MARYSVILLE
PUBLIC WORKS

MEMORANDUM

SUBJECT: PA22-043 White Barn – Lot 8 BSP
Final BSP Review
APN: 00590700030501

WHITE BARN LOT 8 NON-PROJECT BINDING SITE PLAN

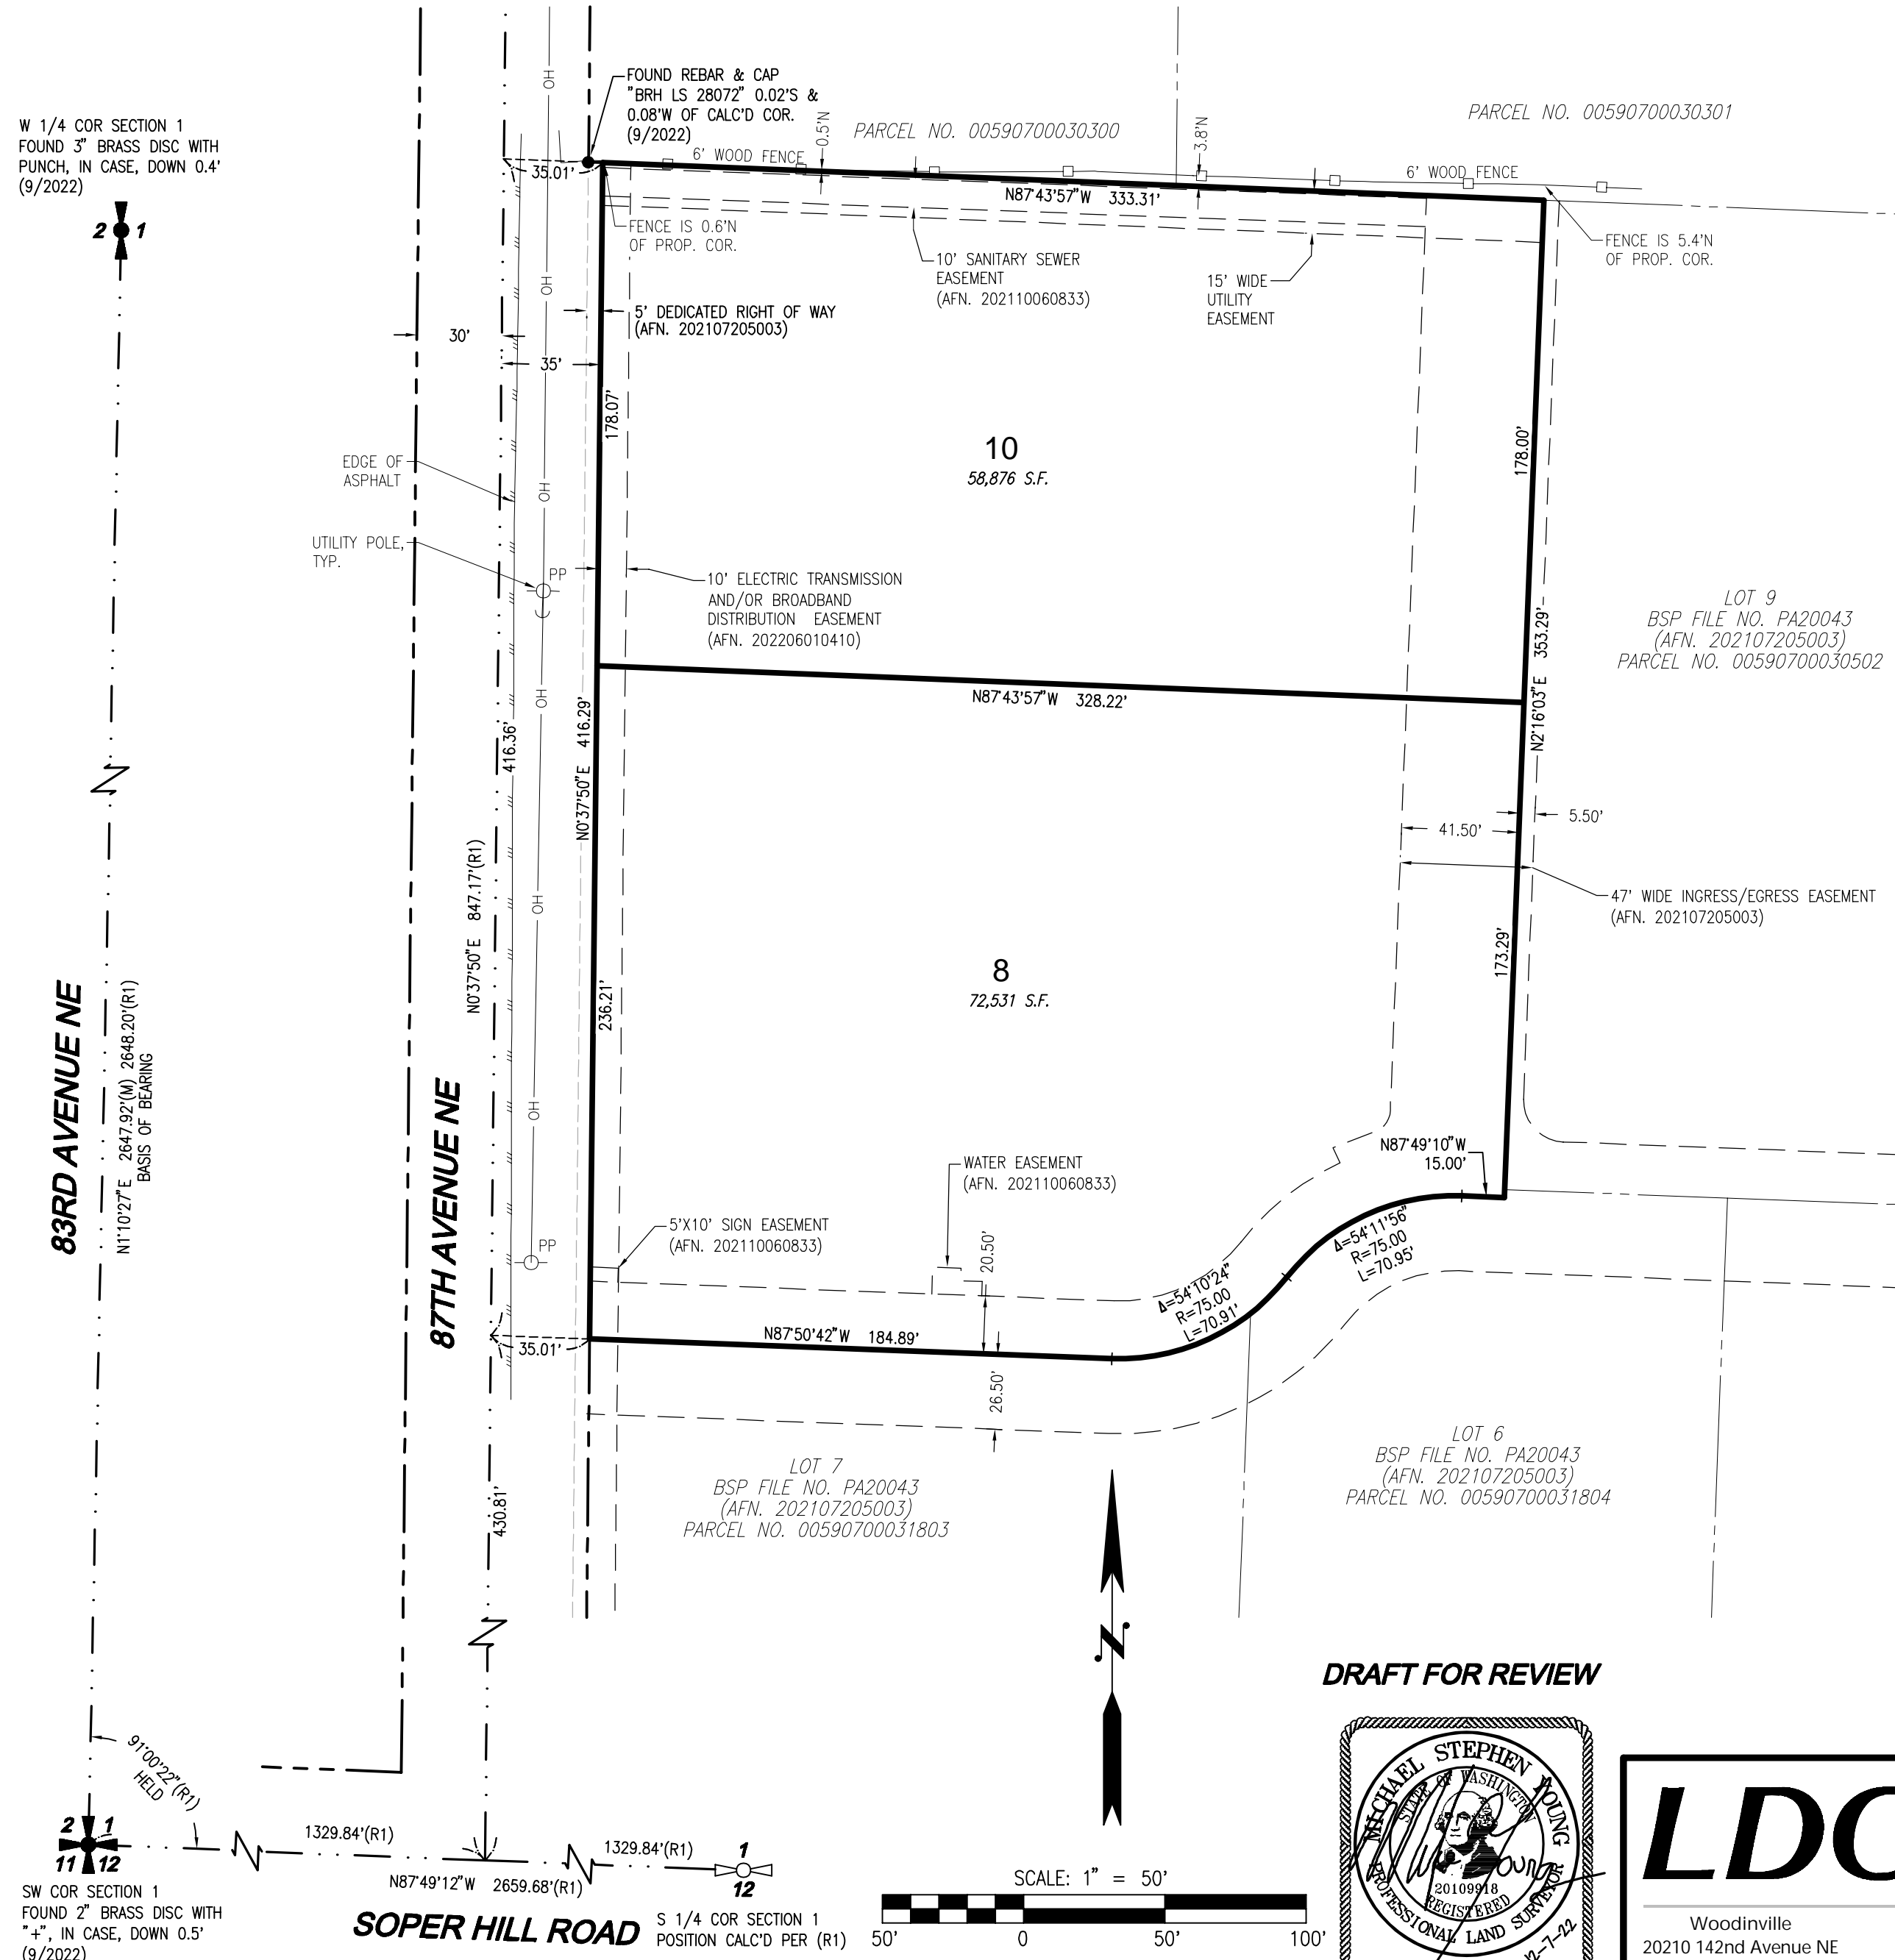
Sheet 3 of the BSP Site Plan contains incorrect values for Lot 8. The West property line is recorded with a value of 236.21' and the East property line is recorded with a value of 173.29'. The corresponding lot lines within the Lot Closure Report are 238.21' (Lot 8 / Segment #1) and 175.29' (Lot 8 / Segment #3), respectively. It appears the values shown in the Lot Closure Report are correct and should be used to correct the discrepancies in the site plan.
